Application for a non-material amendment following a grant of planning permission. Town and Country Planning Act 1990

M/111/14/NMA

Application for a non-material amendment following the grant of planning permission M/87/13/ to extend the approved layout a further 1m into the garden.

Proposed Ground Floor Plan

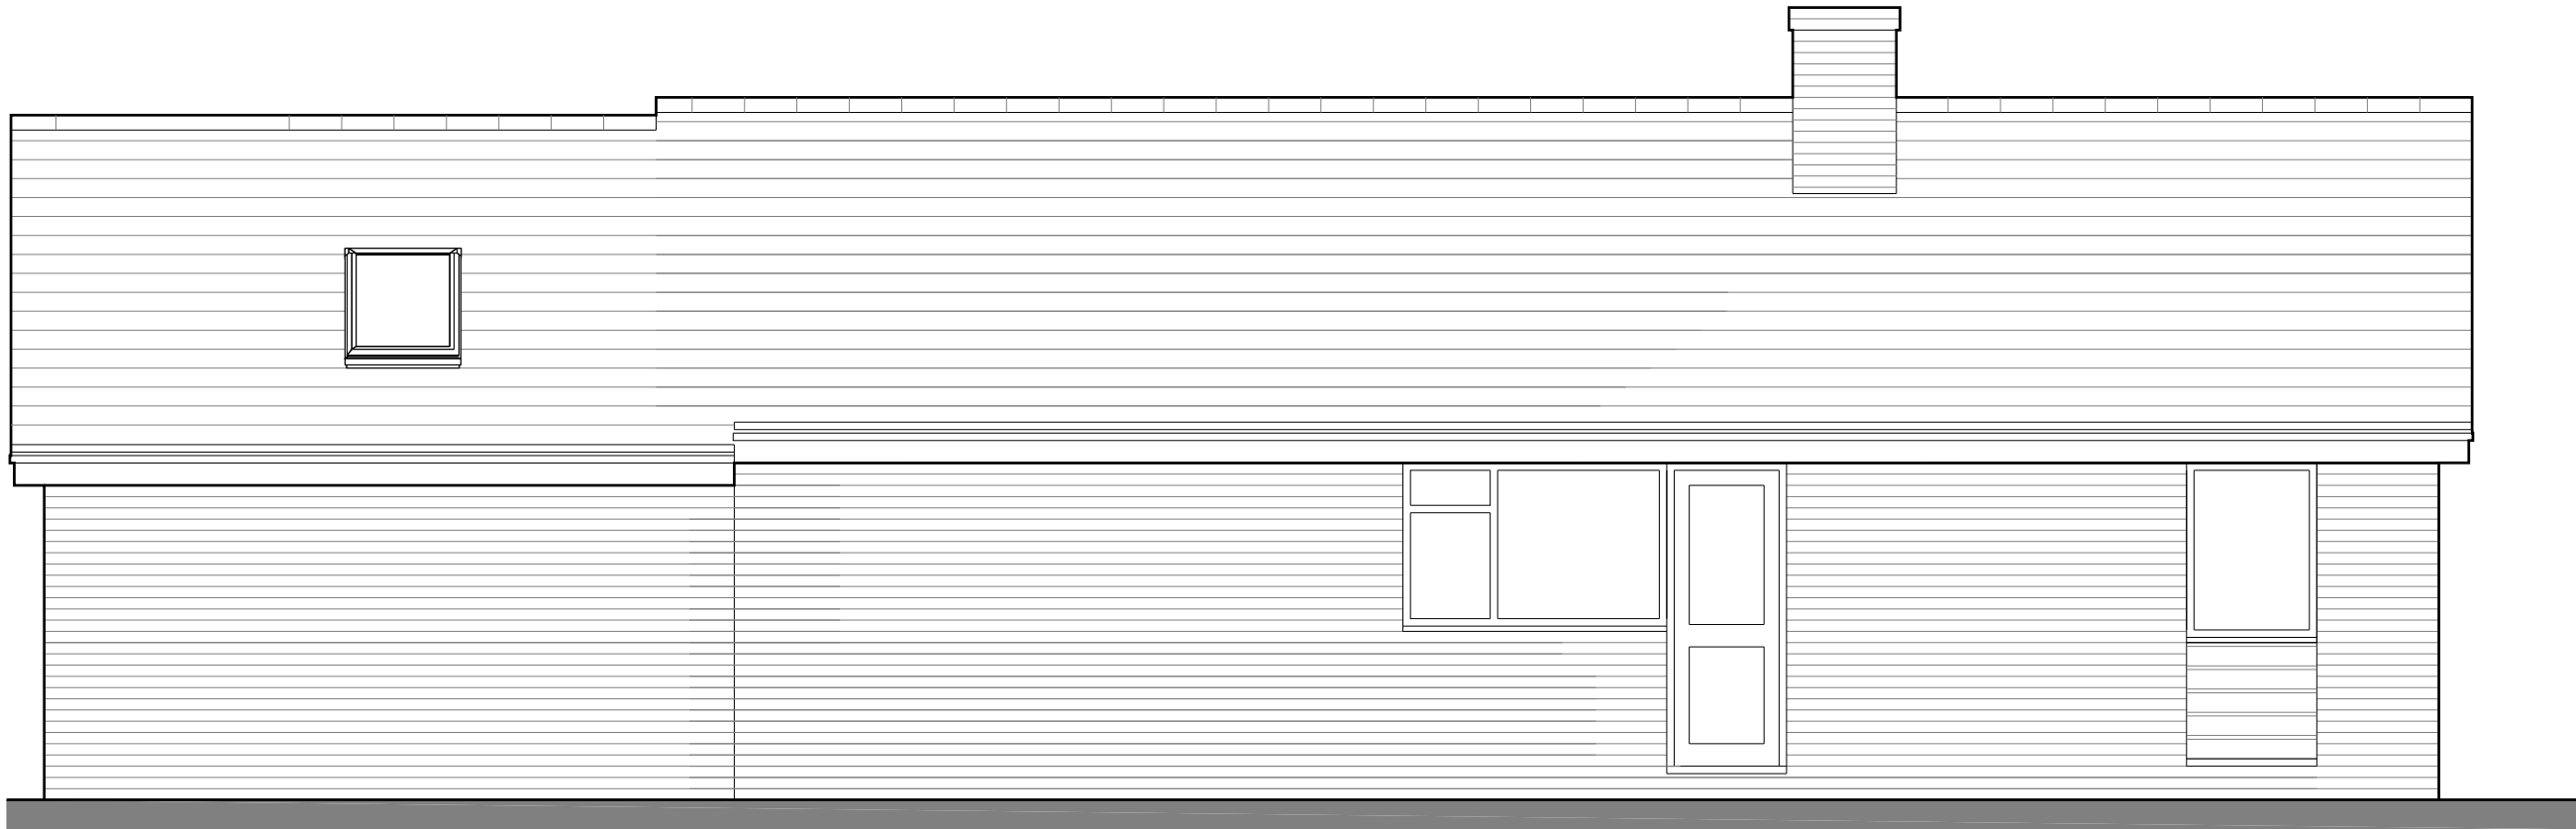
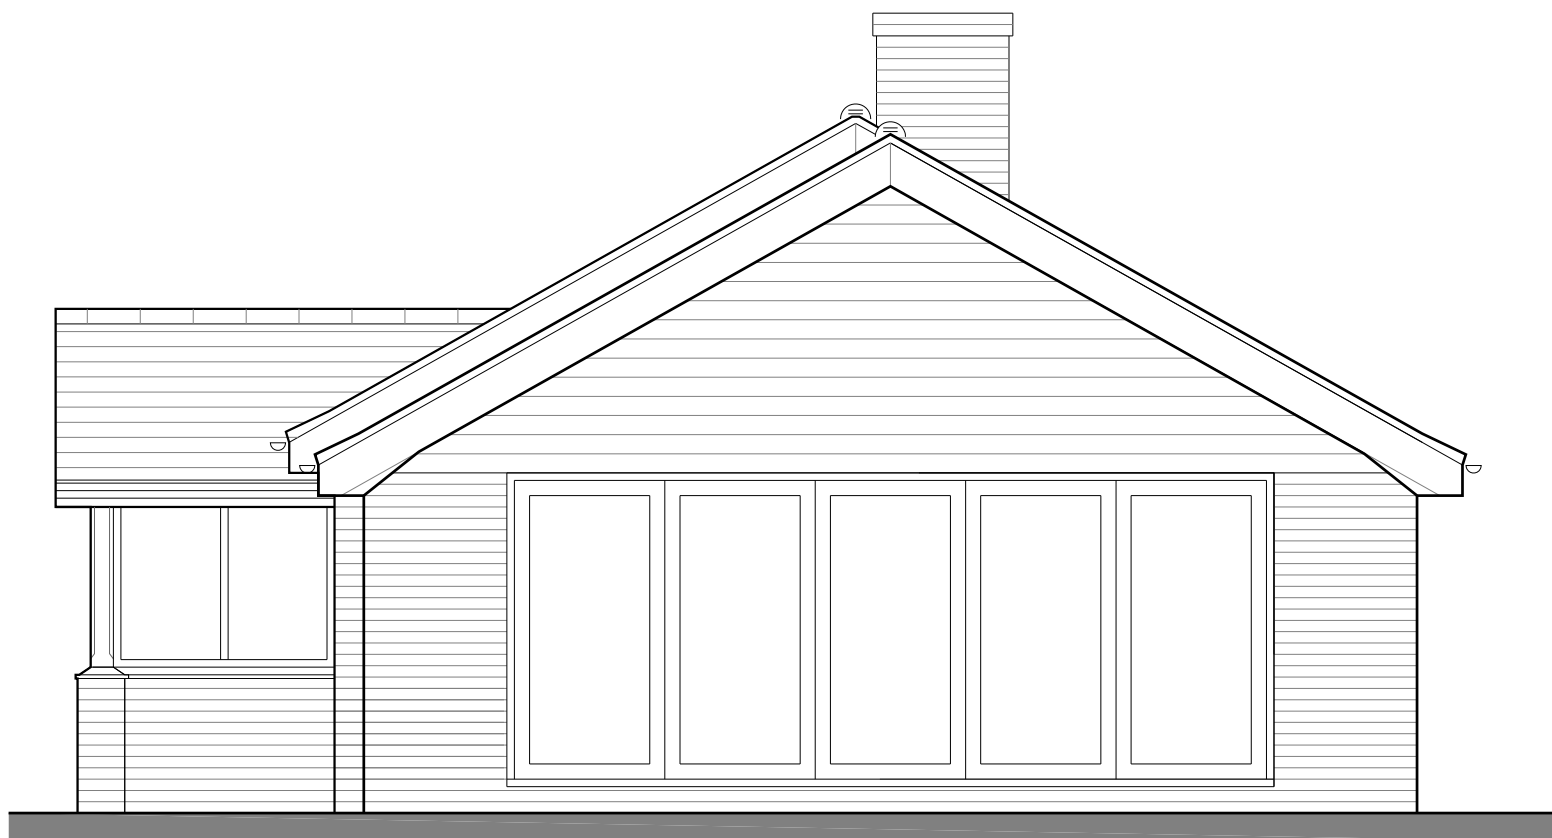
Extend the approved layout a further 1 metre into the garden

Old plan/drawing numbers: 1184 100, 101, & 102

New plan/ drawing numbers: 1184 100A, 101A, & 102A

I have looked at the proposed alteration and on the basis that it does not increase the depth of the extension by more than 1m I can advise that the amendment would fall within our adopted criteria and would be acceptable as a Non-Material Amendment. Without prejudice I would therefore suggest that you submit an application for consideration.
